PLANNING BOARD

July 22, 2015

Project Name: **Bangor Savings Bank Bank/Office building with two lane drive-through**
Project ID: #2015-080
Address: 20 Marginal Way CBL: 113 A 025001
Applicant: Wendy Durrah, Bangor Savings Bank
Planner: Jean Fraser

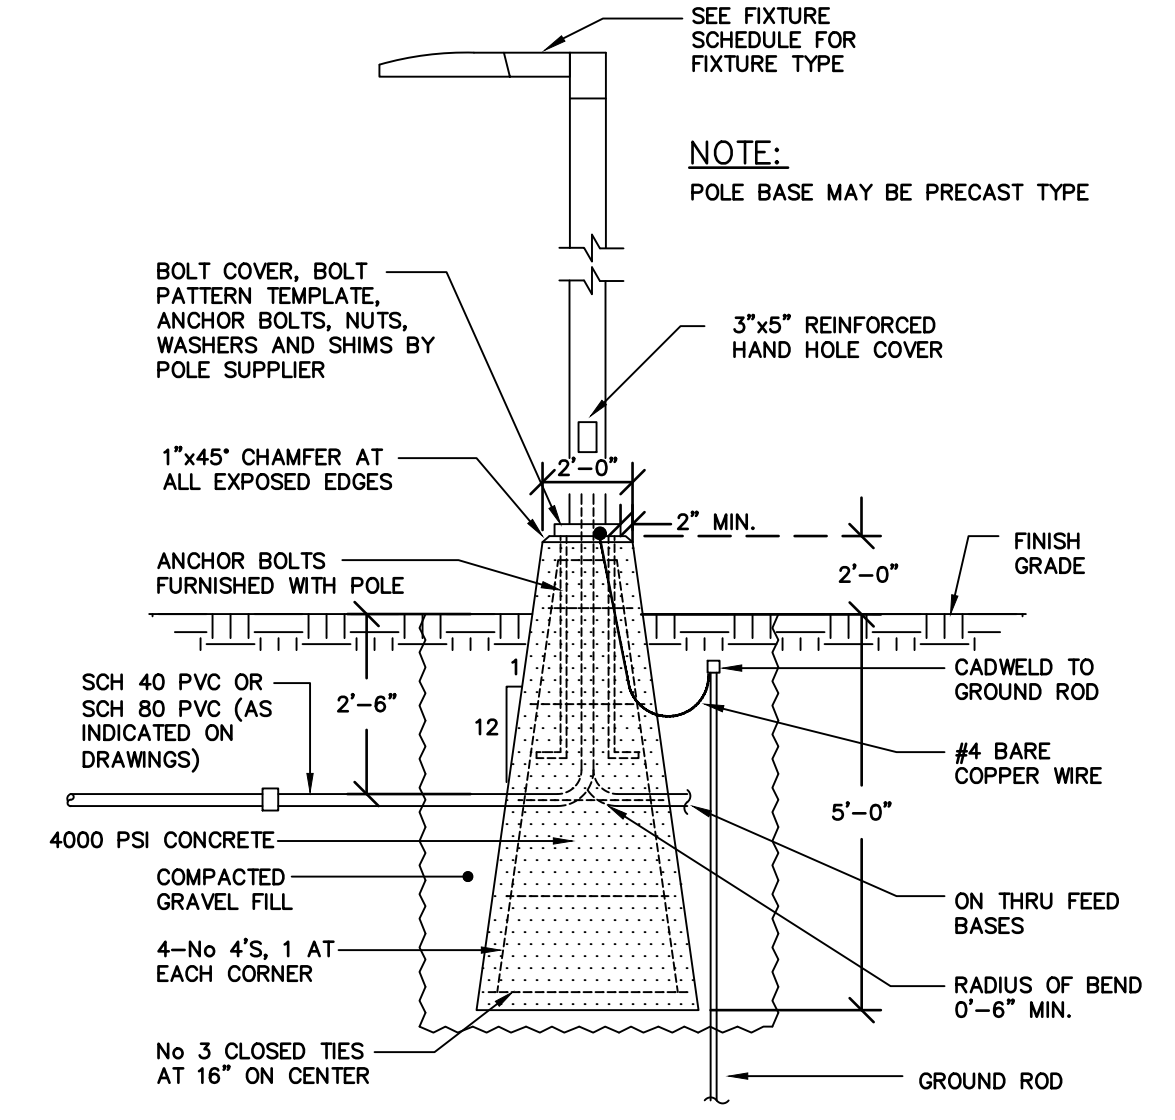
- viii. That the applicant shall submit, for review and approval by the Planning Authority prior to the issuance of a building permit, a revised photometric plan for the rear parking lot area that includes the lighting fixture specification, reduces trespass along the eastern boundary to meet Technical Standards, and increases the lighting levels in the vicinity of the drive-through; and
